Cover Letter - Response to Request for Information #2 for SHL23-014 and SEP23-003 (Evers Pier Repair) 9-14-23

Planning comments dated September 6, 2023 with WCI responses in red below:

REFERENCE #:	
APPLICANT:	ECKHARD EVERS
PROPOSED:	PIER REPAIR
SHEET:	3 OF 14
DATE:	06/28/2022
NEAR/AT:	MERCER ISLAND
DWG#:	21-32061-A6-3

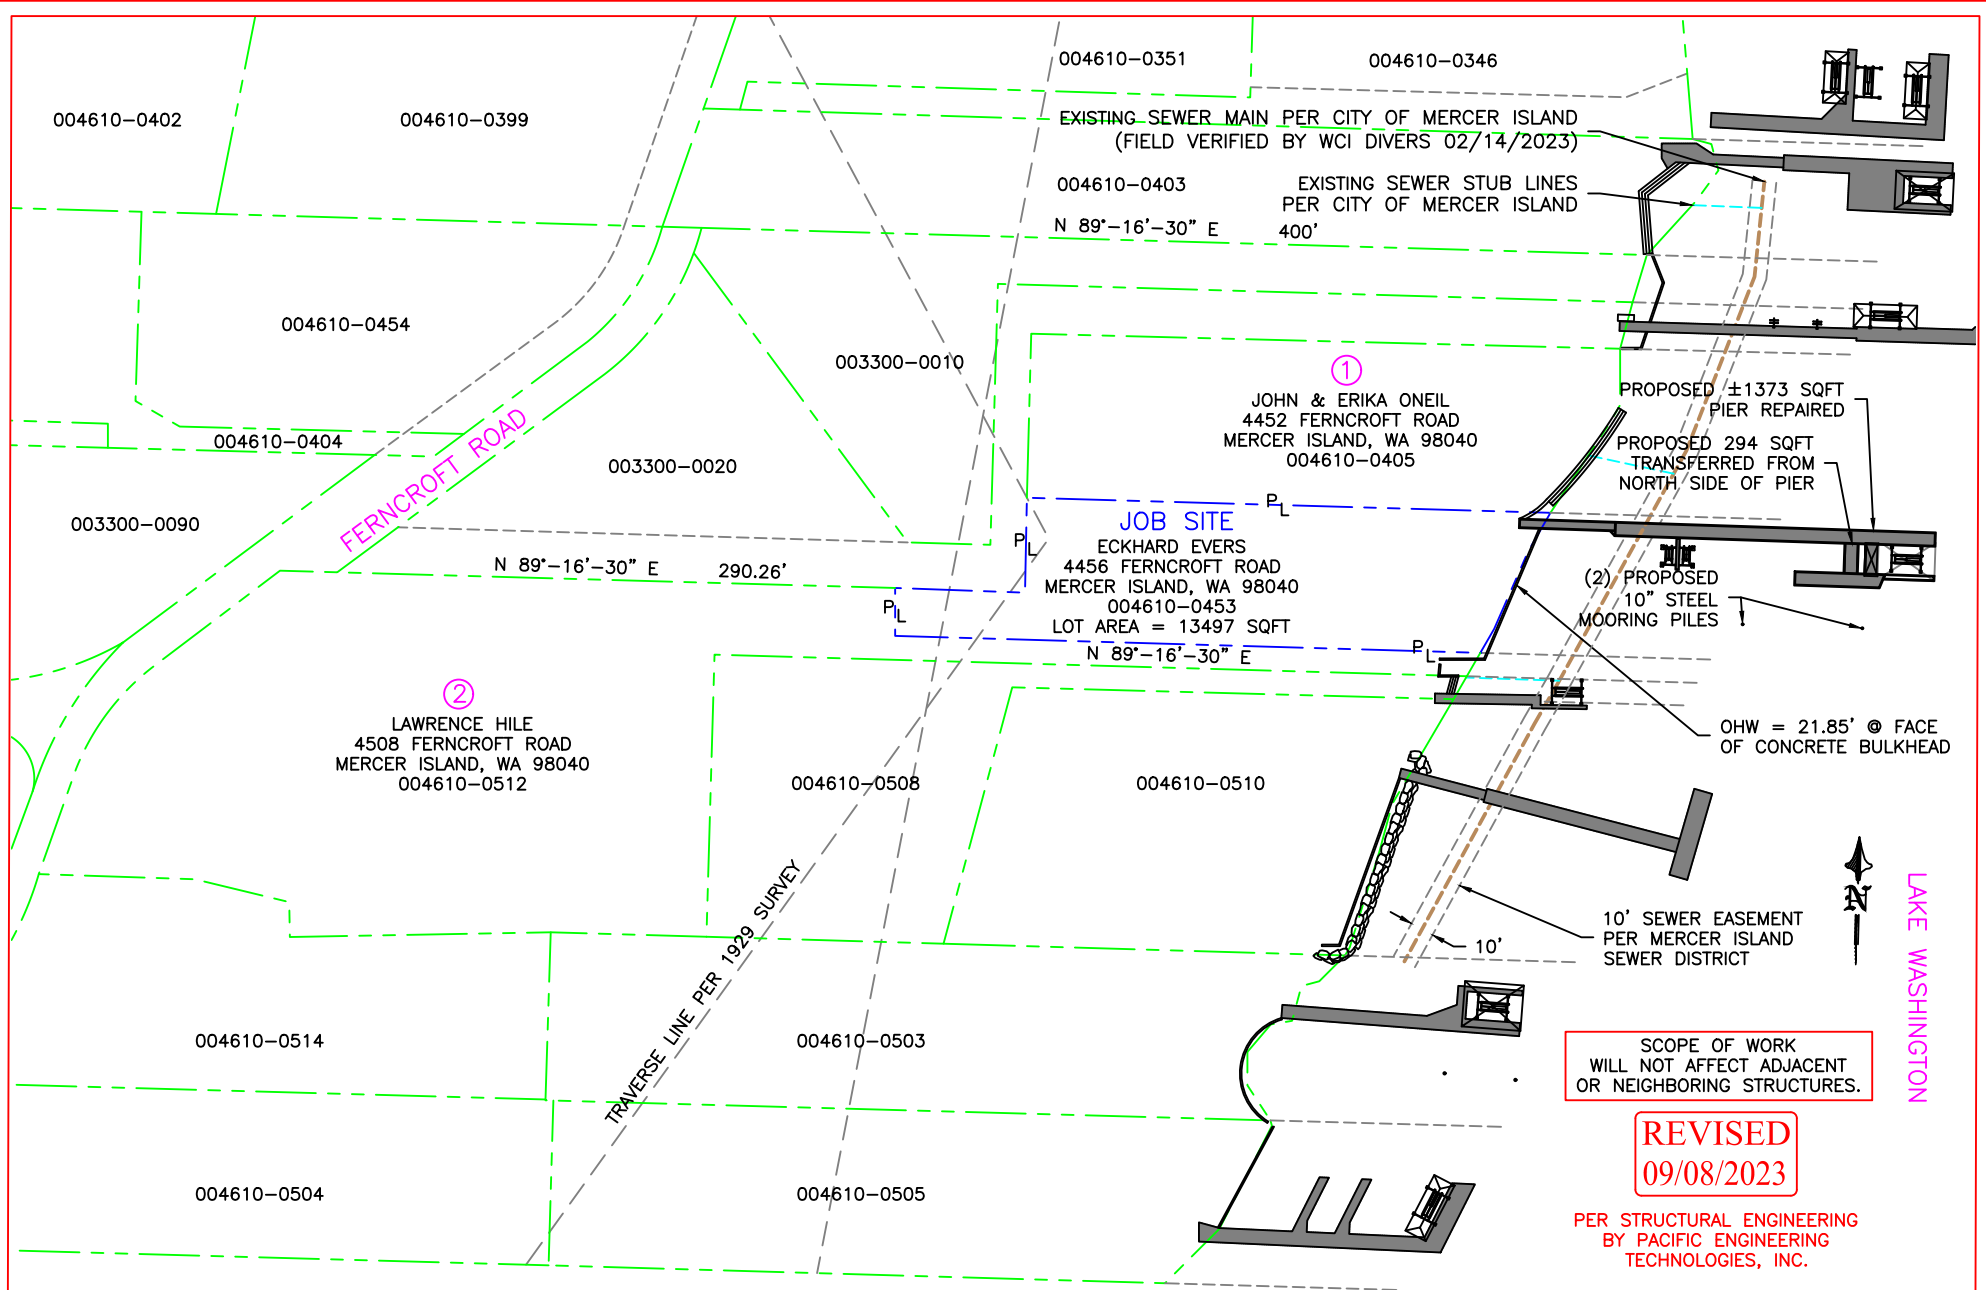
1. No new pilings shall be constructed in the sewer easement. Please relocate all pilings so they are not in the easement.
WCI Response: Pilings have been relocated and will not be constructed in the sewer easement. Illustrated on sheet 3
